**Re: Lot 9, 28 McPherson Street, Banksmeadow (SSD 9691)  
Response to Submissions**

Further to your request we are pleased to provide our response to the civil, stormwater and flooding items raised by Department of Planning, Infrastructure and Environment, Randwick City Council and Bayside City Council in their respective emails and associated information request letters.

SITE PREPARATION PLAN
1:500

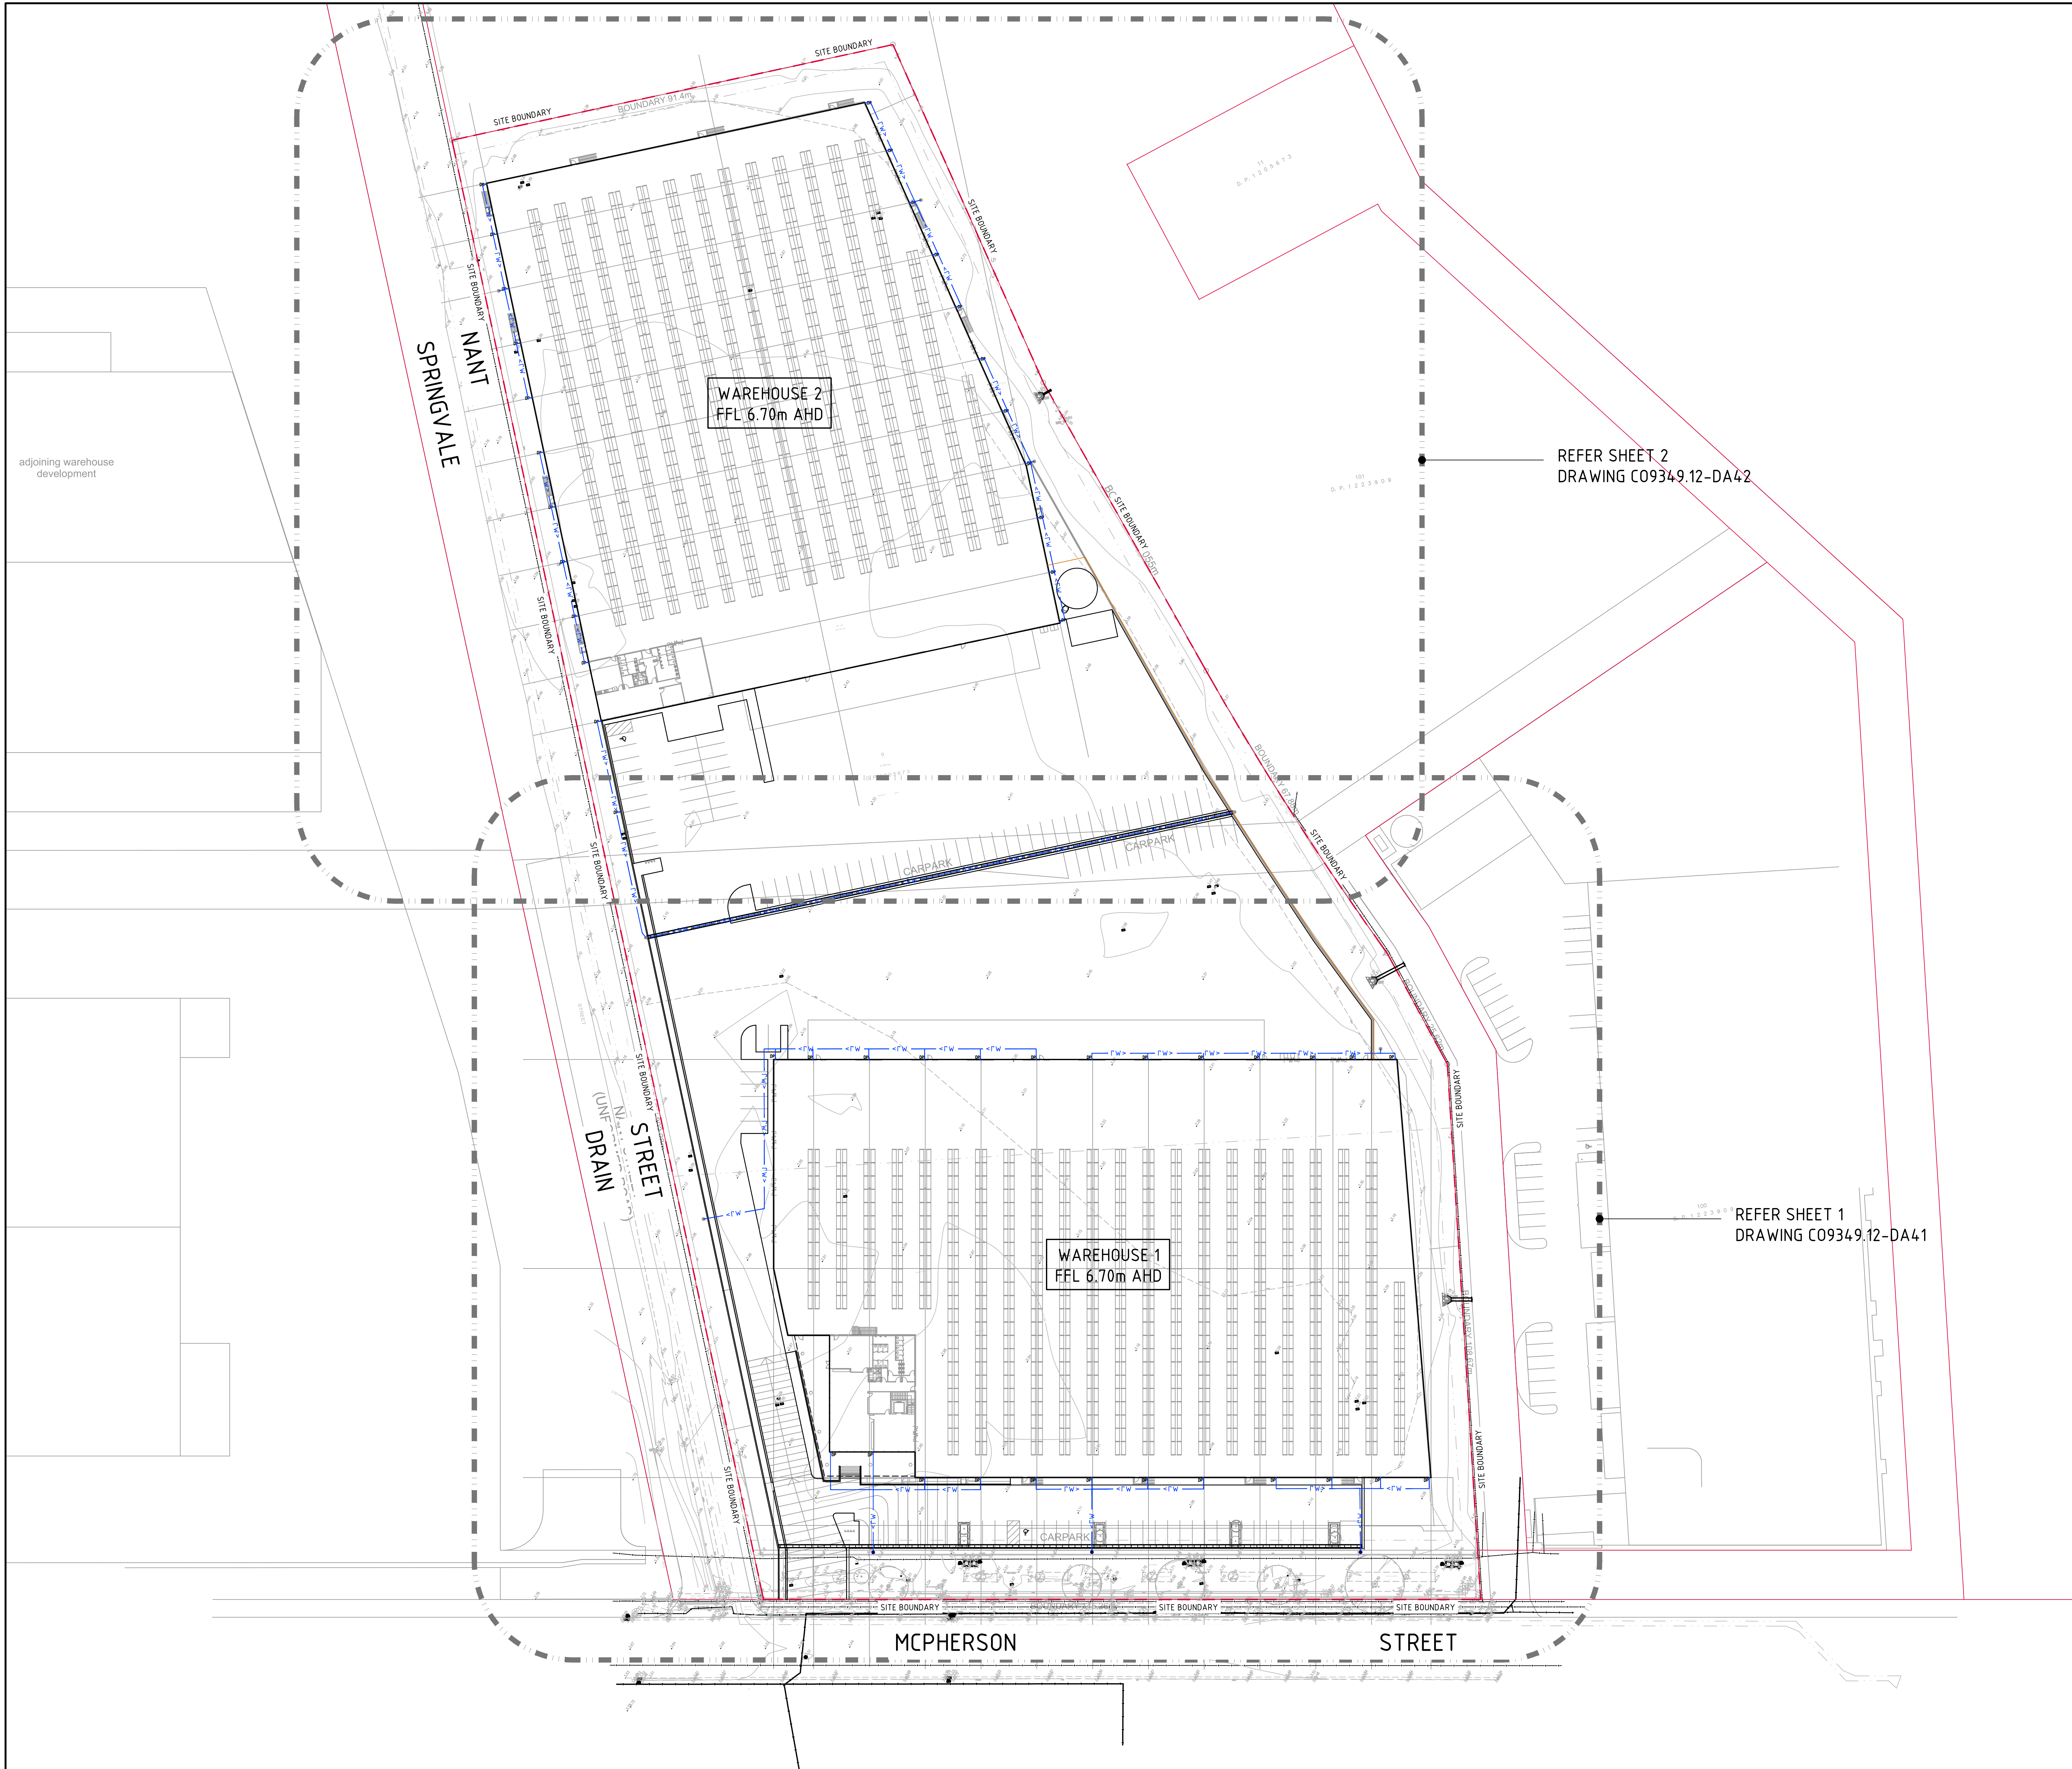
| <b><i>Department of Planning Industry and Environment</i></b> |                                                                                                                                                                                                                                                                                                                                                                                                                                   |
|---------------------------------------------------------------|-----------------------------------------------------------------------------------------------------------------------------------------------------------------------------------------------------------------------------------------------------------------------------------------------------------------------------------------------------------------------------------------------------------------------------------|
| <b><i>Item 2)</i></b>                                         | <p><i>Further details are required on whether the proposed barrier/capping layer will impact the natural permeability of the site and details are required on the potential for the ponding of water below the suspended slab.</i></p> <p><u>Response</u></p> <p>A barrier layer is proposed as a working platform for piling machinery during construction phase and then as a barrier for asbestos management on an ongoing</p> |

|                                    | <p>basis. Refer to <i>Site Preparation Notes</i> included on drawing <b>Co9349.12-DA30</b> for specification of the capping layer.</p> <p>The specification is based on a single graded durable aggregate that will allow water to permeate at greater rates than the natural underlying sands. This will ensure the potential for ponding water below the slab is minimal.</p>                                                                                                                                                                                                                                                                                                                                                                                                                                                                                                                                                                                                                                                                                                                                                                                                                                                                                                                                                                           |

STORMWATER KEY PLAN
1:500

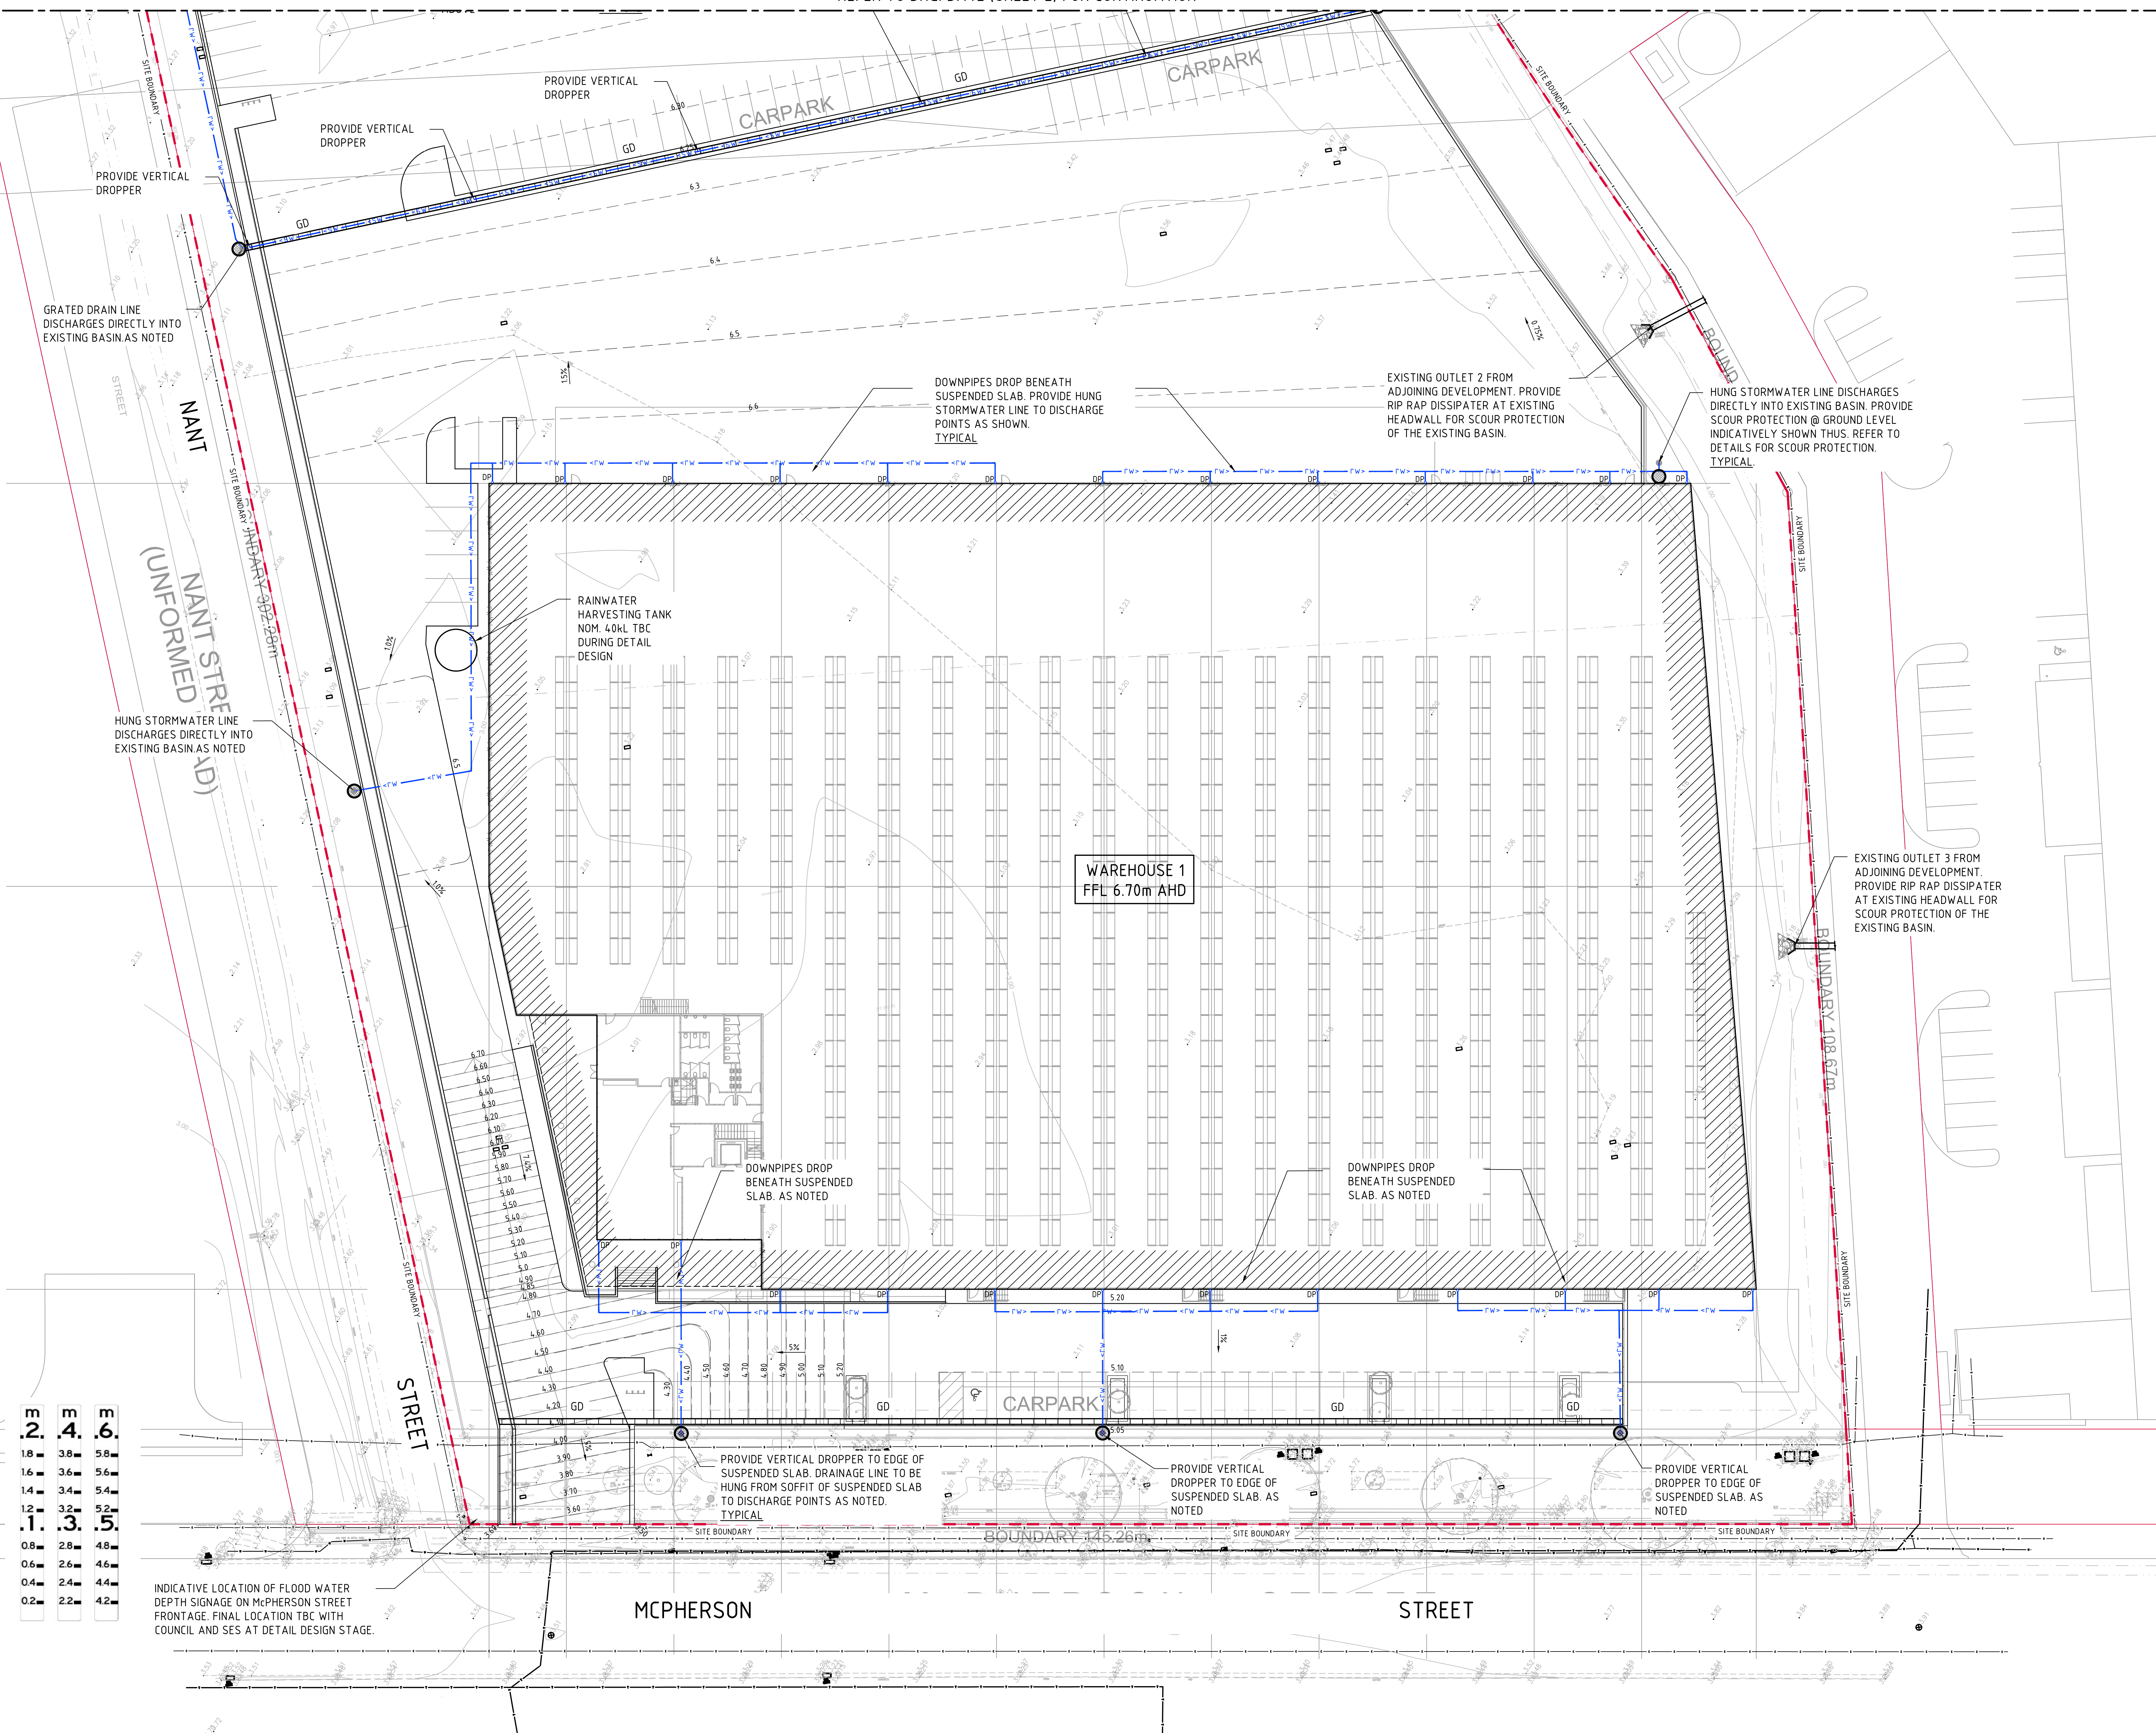
| <b>Item 6)</b>                    | <p><i>The applicant is to liaise with Council and the SES to install flood water depth signs on McPherson Street, both at Springvale Drains and at Floodvale Drains, and in front of the property, to warn road users;</i></p> <p><u>Response</u></p> <p>Refer to updated drawing <b>Co9349.12-DA41</b> showing indicative location of flood water depth sign proposed on the property fronting McPherson Street.</p> <p>Signage requirement to Springvale Drains and Floodvale Drain remains the responsibility of Council and the SES.</p>                                                                                                                                                                                                                                                                                    |
| <b>Item 7)</b>                    | <p><i>The flood storage area under the building will be flooded frequently even in a minor rain event. Access to the undercroft area access must be restricted to avoid risk of drowning. Signage is to be provided to warn the employees and visitors.</i></p> <p><u>Response</u></p> <p>Access to the undercroft area is restricted to unauthorized personnel and confined space requirements. The undercroft area will include a mesh steel fence around the perimeter of the underside of the suspended deck to ensure restricted access and allow flood water to enter and exit unimpeded.</p> <p>Signage will be provided to warn employees and visitors at the access gates that the area is prone to flooding. Refer to updated drawing <b>Co9349.12-DA41</b> and <b>DA42</b> showing location of proposed signage.</p> |

| <b>Item 9)</b>  | <p><i>The locations and specifications of water quality treatment devices need to be shown on the civil engineering plans; and</i></p> <p><u>Response</u></p> <p>Refer to revised drawing <b>Co9349.12-DA41</b> and <b>DA42</b> for the proposed water quality treatment devices which include rainwater harvesting tanks.</p>                                                                                                                                                                                                                                                                                                                                                                                                                                                                                                                                                                                                                                                                                                                                                                                                                                                                                                                                                                                                                                                                                                                                                                                                                                                                                                                                                                                                                                                                                                                                                                                                                                                                                                                                                                                                                                                                 |
